Subject: SP-26-00009 Boitano - Notice of Application

Please review the following Short Plat application: SP-26-00009 Boitano. Any comments need to be received by **5PM on September 28, 2026**.

TO: All Staff
FROM: Public Works Plan Review Team
DATE: September 22, 2026
SUBJECT: SP-26-00009 Boitano

SHEET 1 OF 3

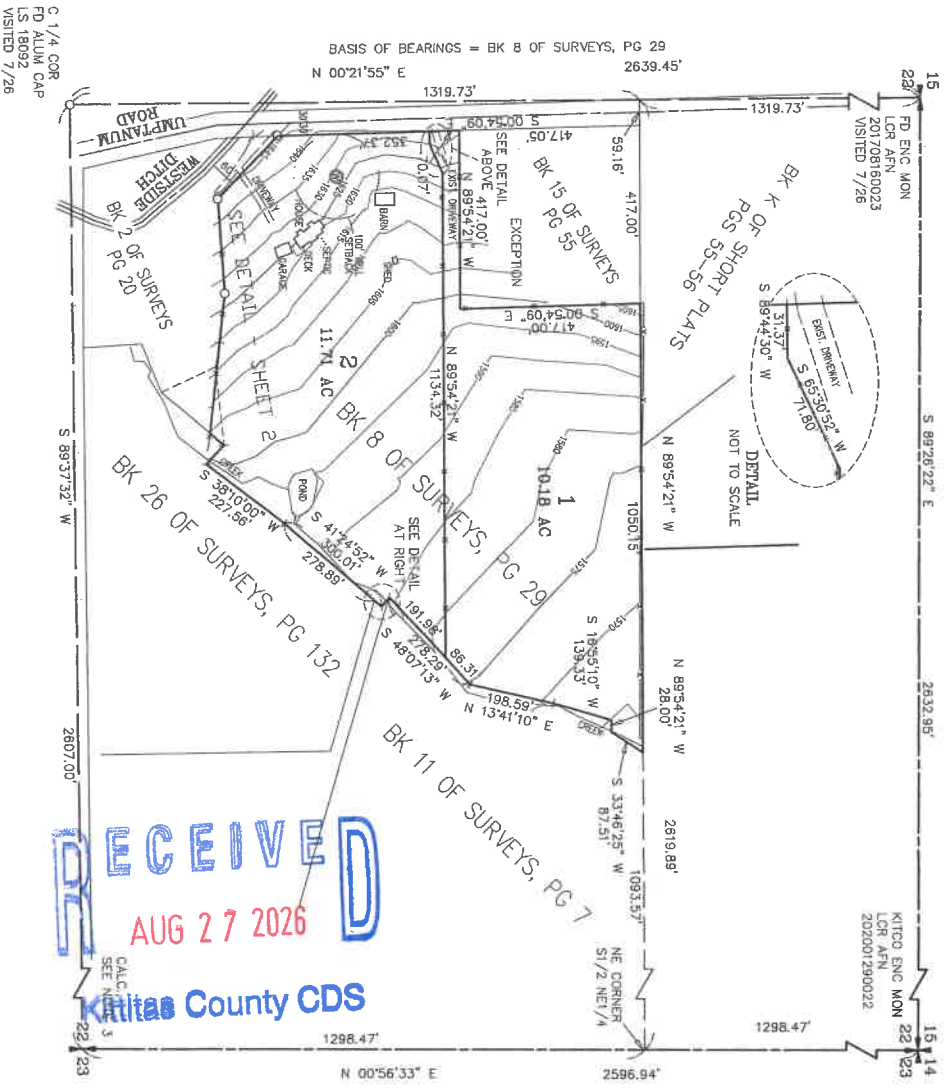
Drinking Water	• An Adequate Water Supply Determination is required for the proposed short plat pursuant to KCC 13.35.020(2). • The preliminary plat identifies the source of water as a shared well. The proposed shared water system must meet the requirements of KCC 13.35.060, including a valid Shared Well Users Agreement and documentation demonstrating adequate water quality and quantity. • The existing well must maintain the required 100-foot Water Supply Protection Zone. During the previous well site inspection, the existing barn was measured at approximately 99 feet from the well head. The portion of the barn within the 100-foot protection zone will need to be relocated, rebuilt, or otherwise modified to provide the required separation.
Wastewater	• Soil logs must be completed for each proposed lot.

SURVEY	There are no critical comments preventing the acceptance of this preliminary Short Plat. Comments below are in regards to final. 1. Property corners will need to be set in the field and shown on the face of the Short Plat. 2. There may be a typo in the distance tie from N1/4 corner to S boundary at center of road (2130.9 on map, 2130.09 in legal description) 3. Applicant is asked to review existing parcel 2 description. From the existing legal description, It appears that the small sliver located between bearing S83°41'31"E and S80°16'04"E should remain as part of the subject property. (JT)
TRANSPORTATION CONCURRENCY	Not applicable for this proposal. (CBP)
